## MEMORANDUM

**Subject:** Application ID: 2013-228

**Date:** 12/6/2013

**Comments Submitted by: Marge Schmuckal/Zoning on 12/6/2013**

DRAWING NAME: **SITE LAYOUT PLAN**
 PROJECT NAME: **MUNJOY HEIGHTS**
 CLIENT: **REDFERN MUNJOY, LLC.**
 P.O. BOX 8816, PORTLAND, MAINE 04104

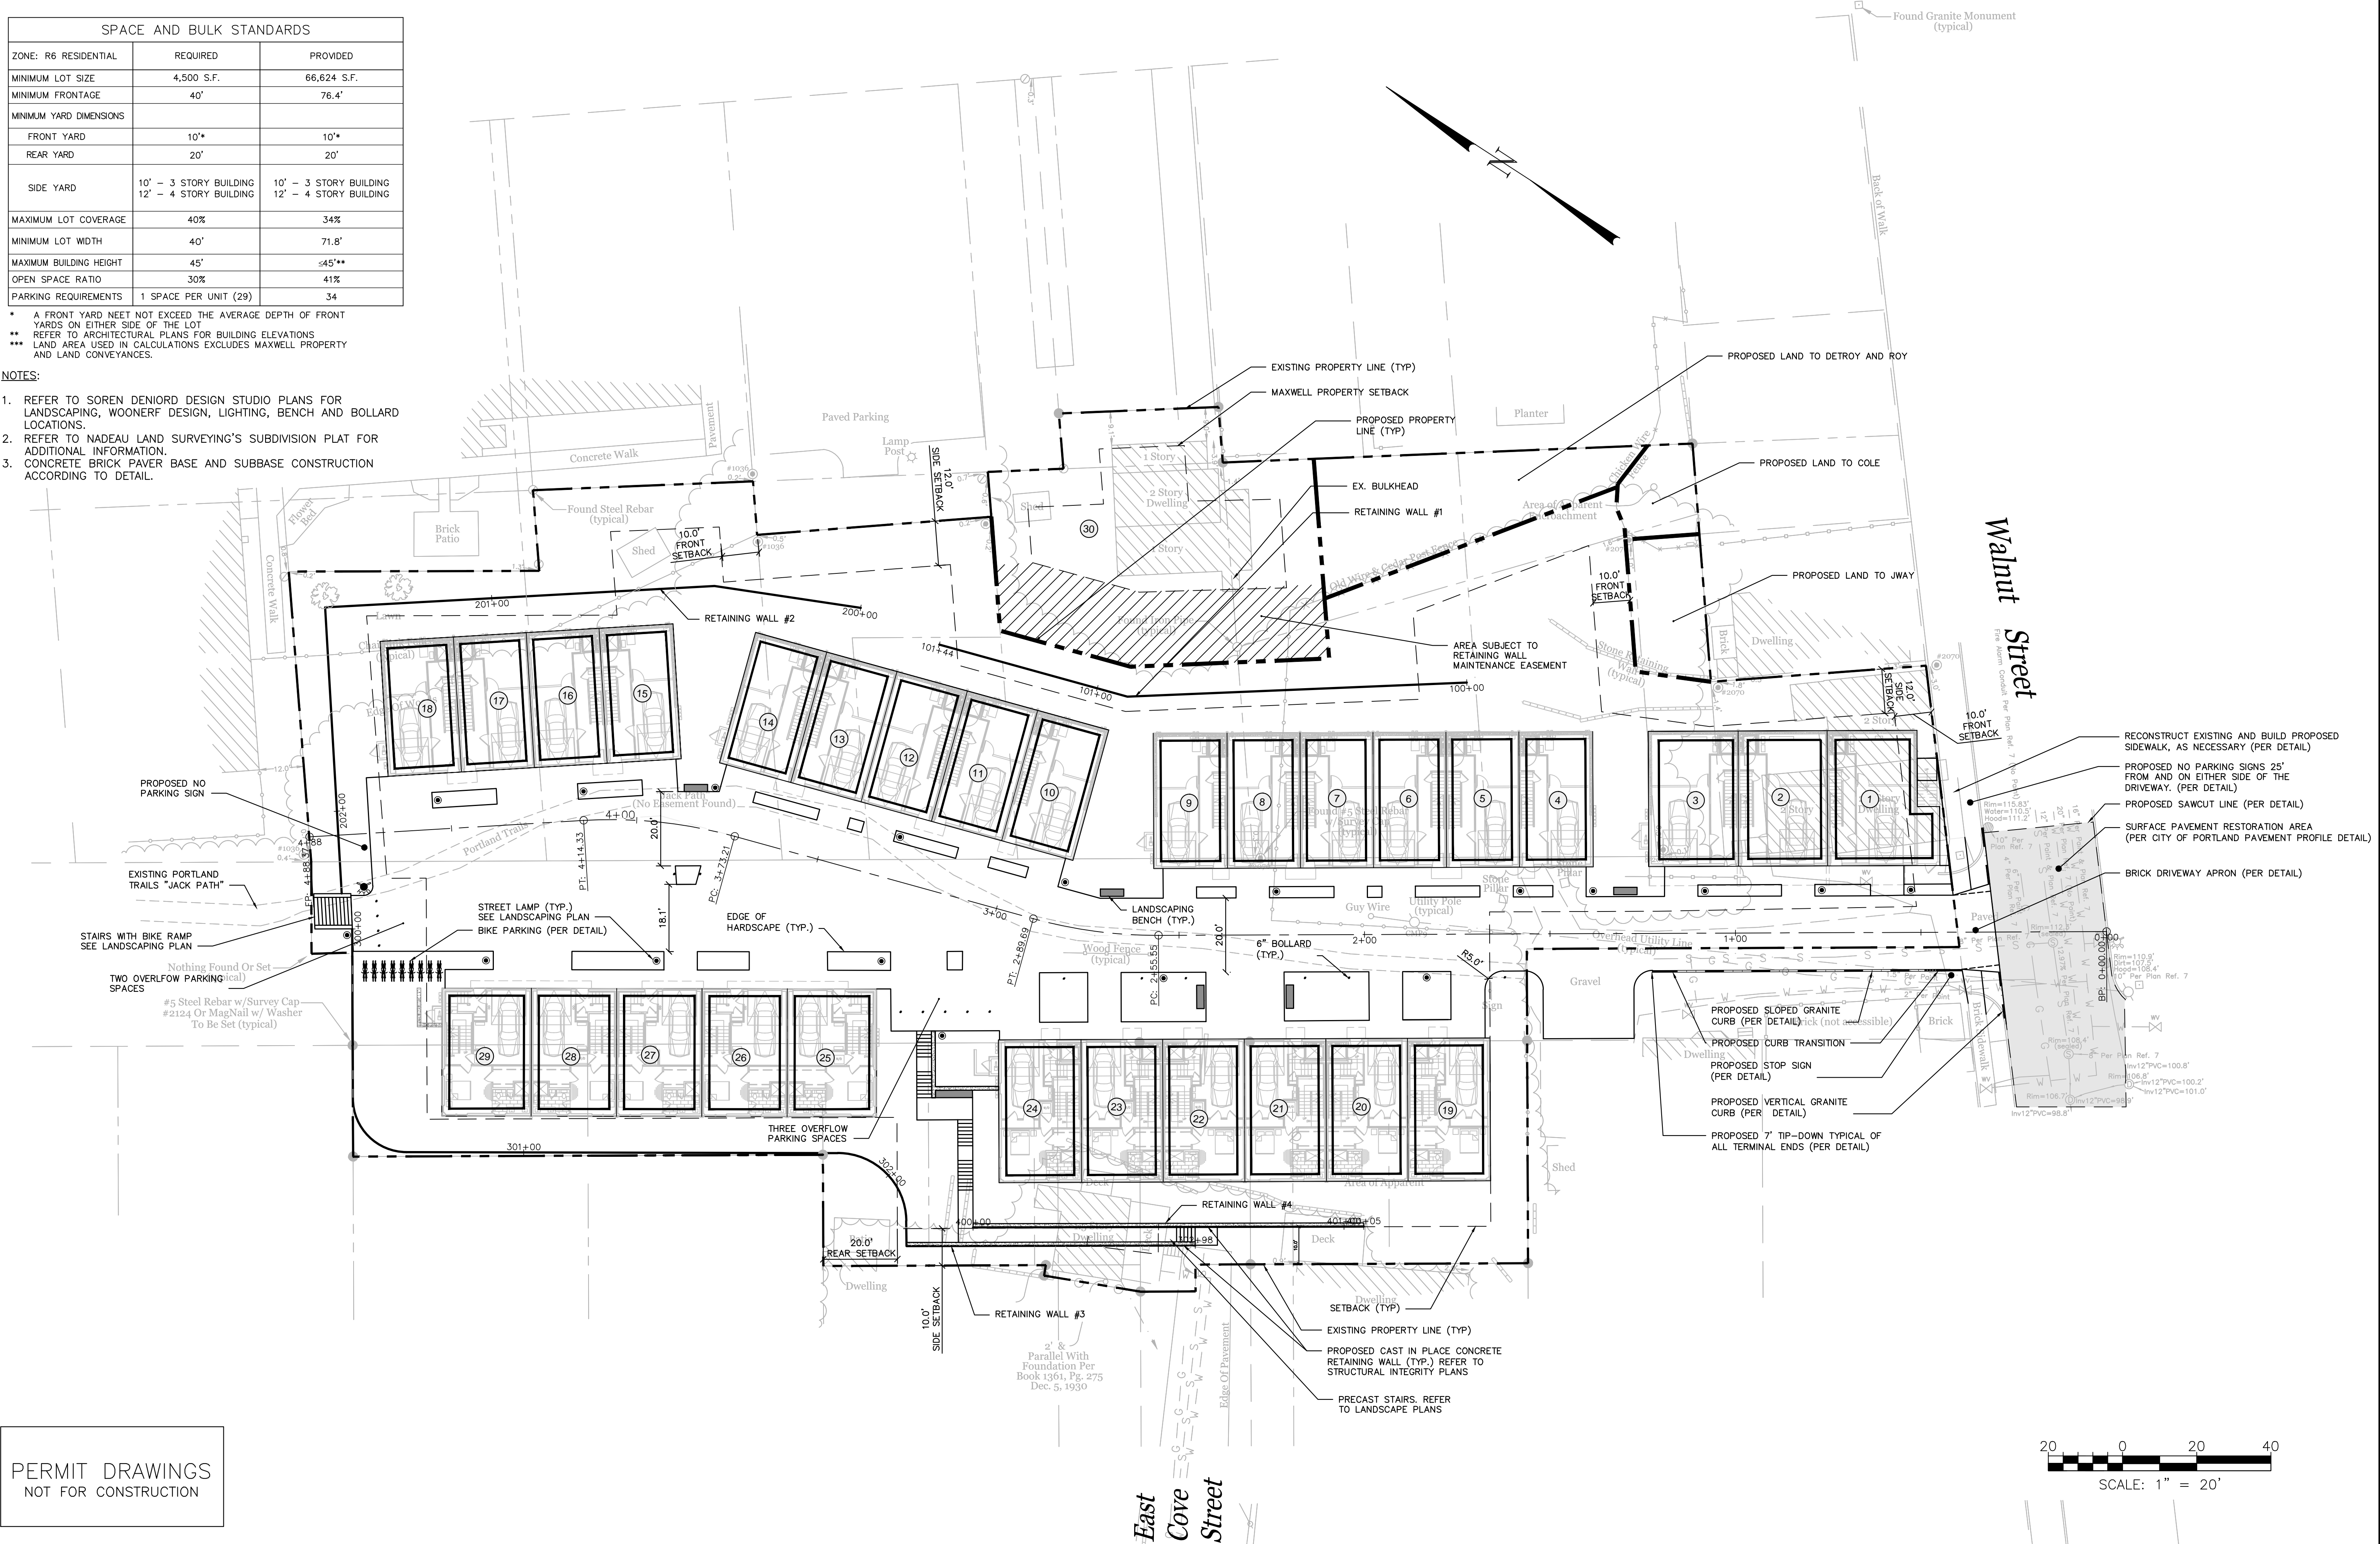
Marge's original review comment on 10/18/13 stated that the height requirement appeared to be met, but that the narrative had mentioned average grades, She wanted to see the methodology for the average grade. Based on the email from Ryan Senatore and the Average Grades Diagram dated 12.04.13, the methodology has been shown and the heights for the three story and four story buildings from the average grade is below the 45' maximum height requirement.
